Sent: 20 February 2012 14:30
To: Planning
Subject: Planning application N6/2011/2784/AD - 41 Howardsgate

Response to Planning application from Hertfordshire County Council (T and CP GDP Order 1995)

District ref: N6/2011/2784/AD
HCC ref: WH/55/2012
HCC received: 02/02/2012
Area manager: James Dale
Case officer: Lindsey Lucas

Erection of three signs

AUSTIN REED

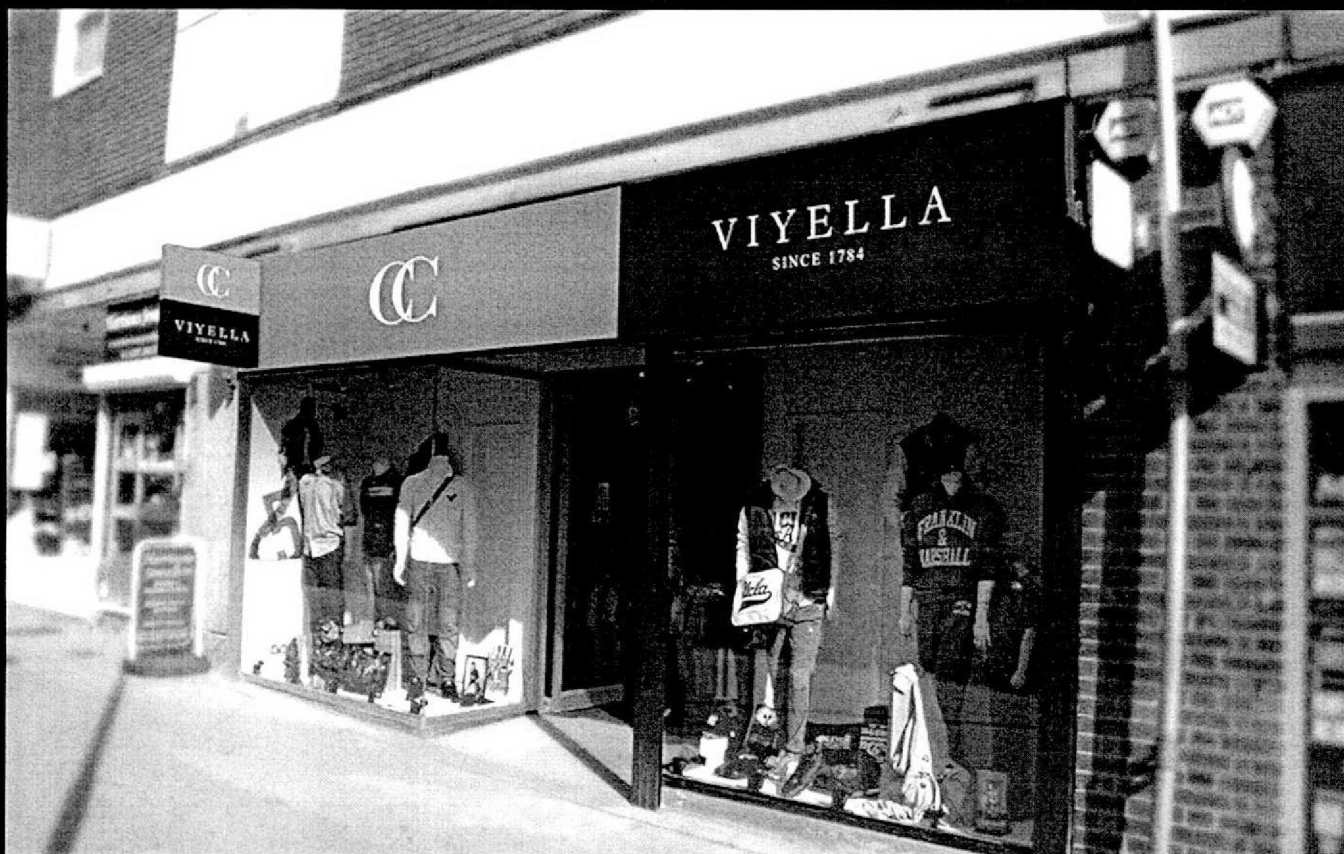
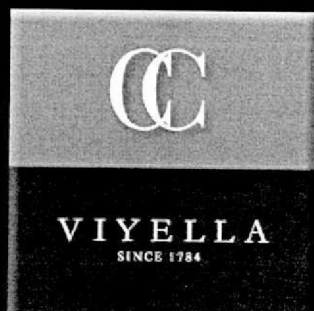
1. All parts of the projecting signage must be at a height of, or greater than 2.1 m vertically above the footpath and no less than 500 mm horizontally from the edge of the carriageway. Reason: In the interests of pedestrian/highway safety and convenience.

COMMENTS: The proposed signage has no implication on highway safety and as shown and conditioned would not affect the free passage of pedestrians.
